Appendix A – Submissions Register – DHL South

1 Responses to Submissions

This section provides a detailed summary of the Applicant's response to the issues raised in submissions to SSD-70818708.

1 CARPARK GROUND - WH 04 1 : 250

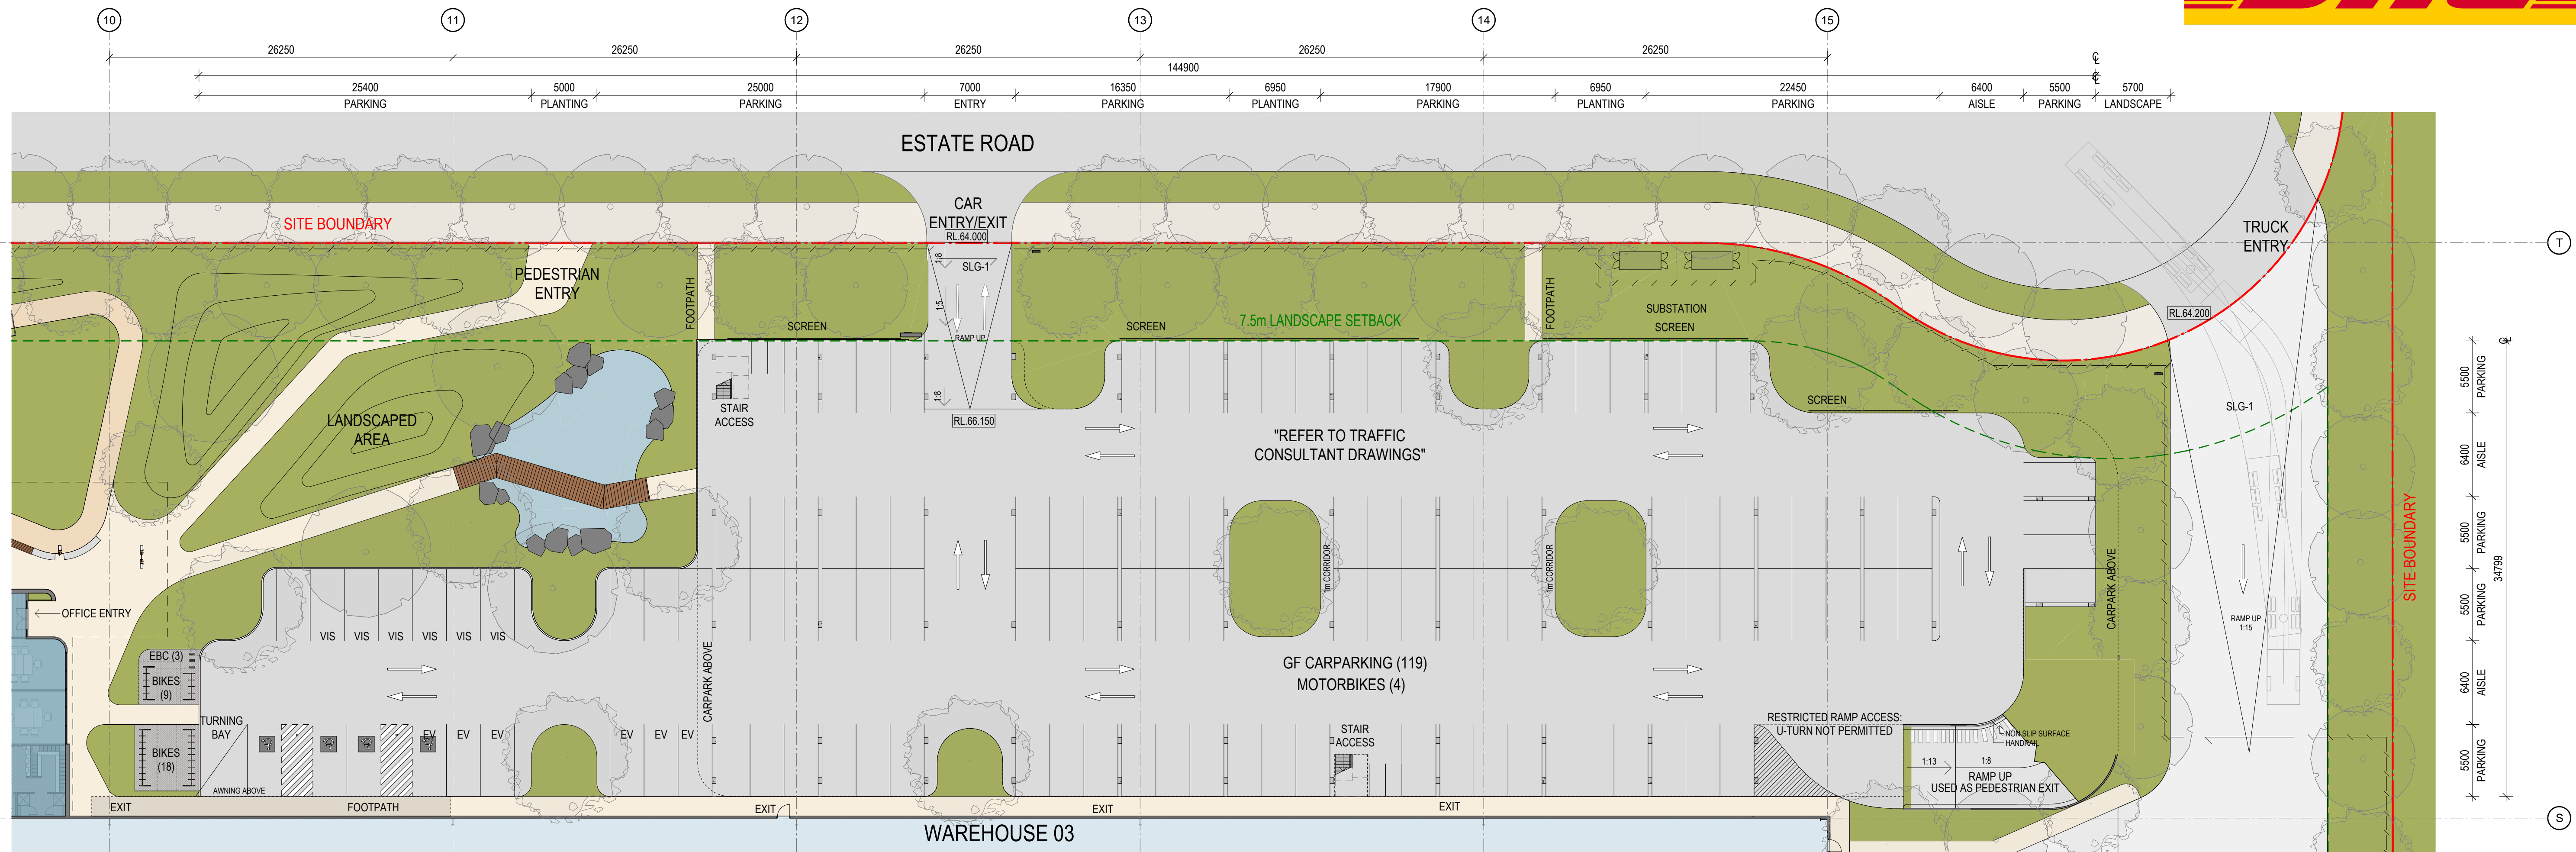
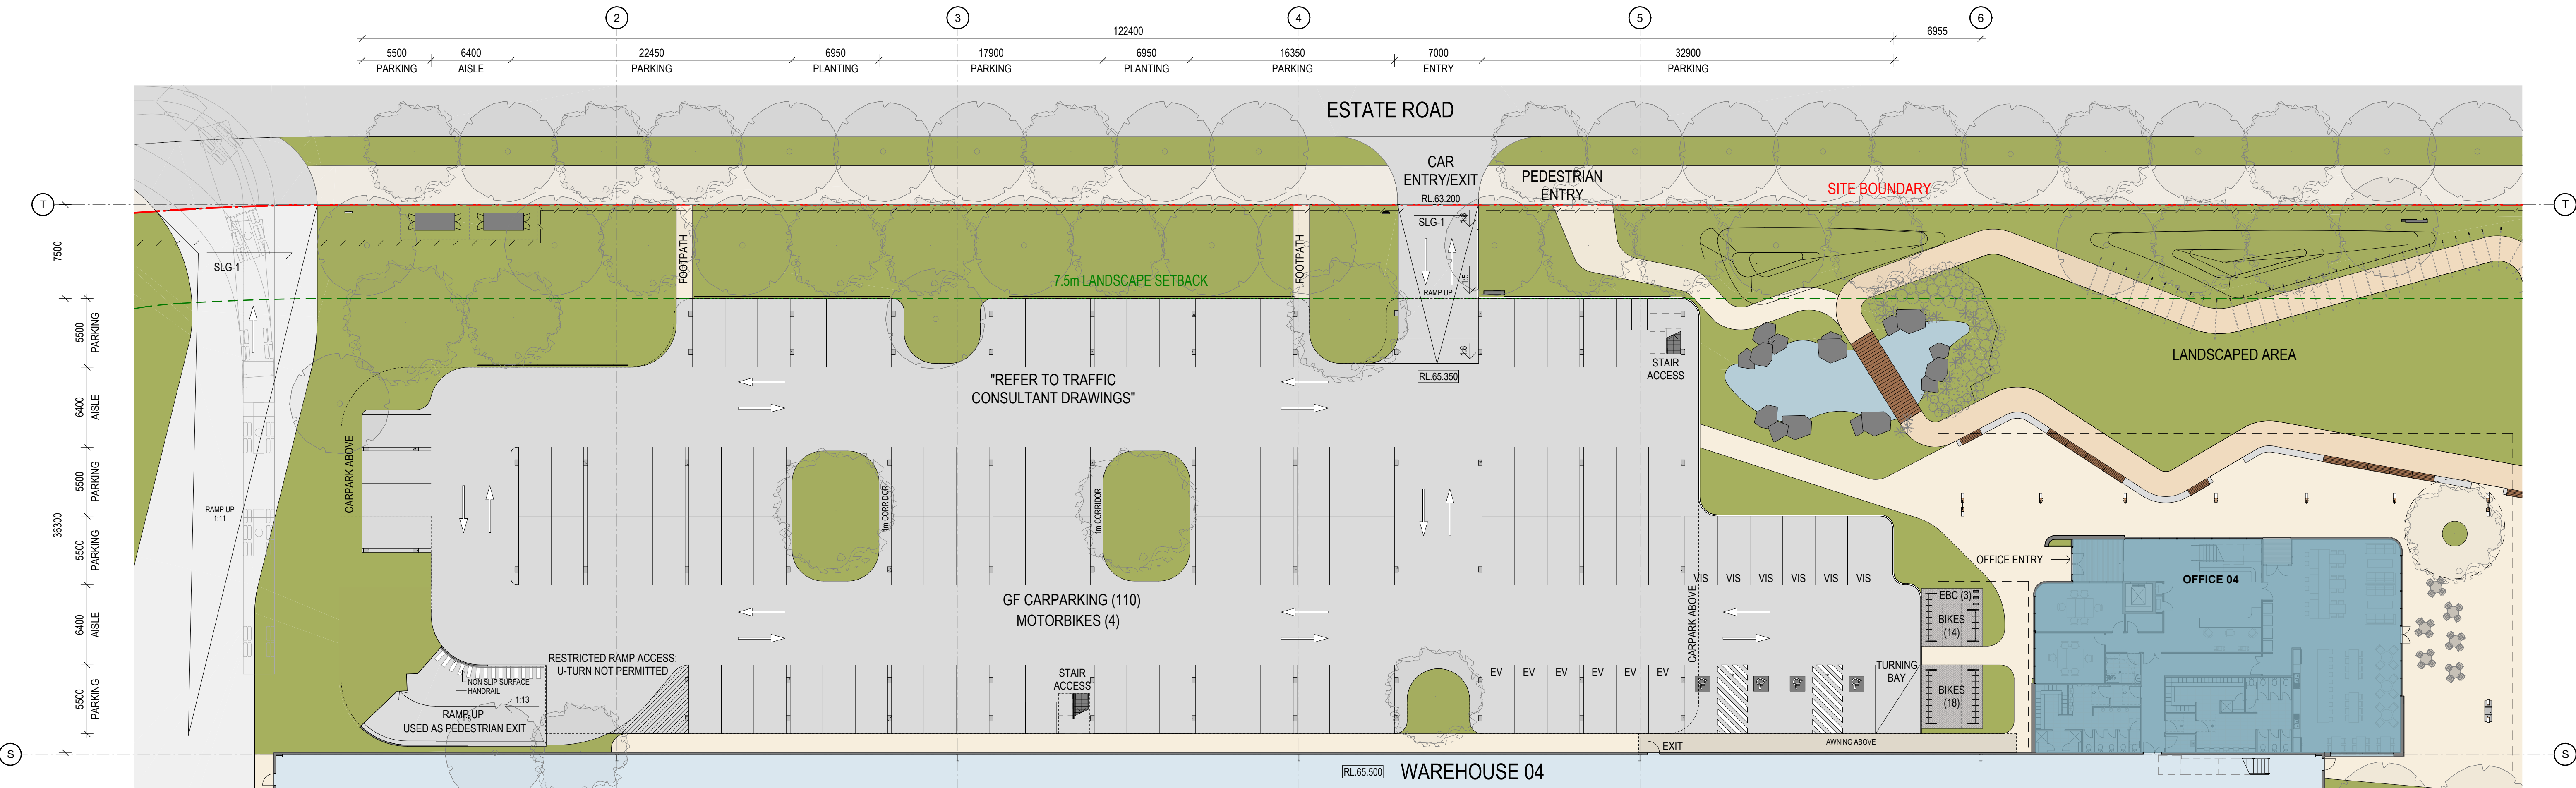
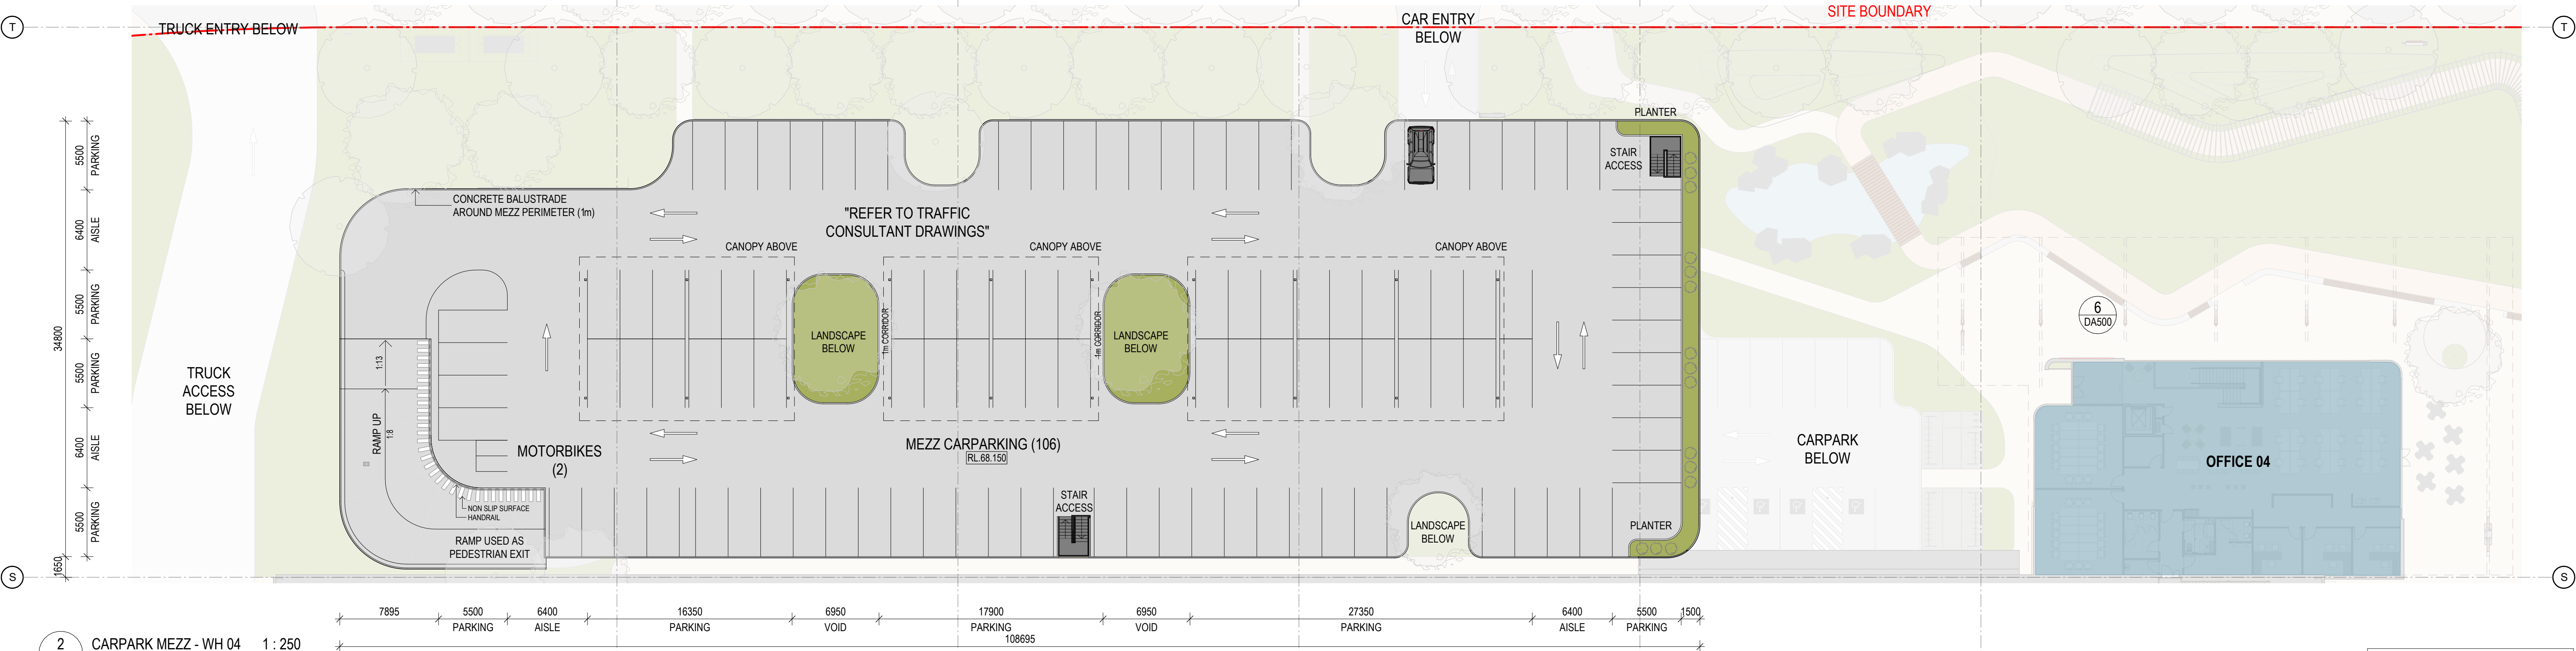
Architectural Plans			
7	All elements of the proposed buildings should meet the setback requirements in Table 6 of the Western Sydney Aerotropolis Development Control Plan (Aerotropolis Phase 2 DCP). This includes the proposed two storey car park structures proposed for each warehouse, which are currently set back 6m from the lot boundary. It is considered that applying the relevant building setback to these structures is more appropriate given their form and their location in front of the warehouses. This would also improve the presentation of the development to the street, provide for opportunities for increased landscape screening and reduce the visual impact of having a bulky	All elements of the proposed buildings meet the setback requirements in Table 6 of the Western Sydney Aerotropolis Development Control Plan (Aerotropolis Phase 2 DCP). Notably, the two storey car park structures are proposed to be set back 7.5m, compliant with the DCP requirement. Refer to Section 3.2.1 of the Rts Report and the updated Architectural Plan at Appendix B .	Section 3.2.1 of the Rts Report and the updated Architectural Plan at Appendix B

No.	Issue Raised	Applicant Response	Reference
	structure closer to the street than the proposed offices.		
8	In addition to the above, please also provide further detail on the design and embellishment of the car park structures to improve presentation to the street and integrate with the overall design of the building, with regard to section 3.3.4 of the Aerotropolis Phase 2 DCP.	The two storey car park structures are proposed to be set back 7.5m, compliant with the DCP requirement. Additionally, the carpark façade will feature either/or permeable panelling or a partial planted green wall to provide screening to the carpark façade. This, in addition to the landscape treatment of the carpark surrounds, including trees and shrubs, will improve the presentation of the building to the street as per the DCP.	Appendix B
9	Provide details of any illumination of signage, lighting and fencing with regard to sections 3.4, 3.5 and 3.6 of the Aerotropolis Phase 2 DCP.	The signage plan is provided in Updated Architectural Plans (Appendix B), there are no changes to the signage details as exhibited and no illuminated signage is proposed. The architectural plans have also been updated to include further details on the location of boom gates as they interface with the fencing across the site.	Appendix B
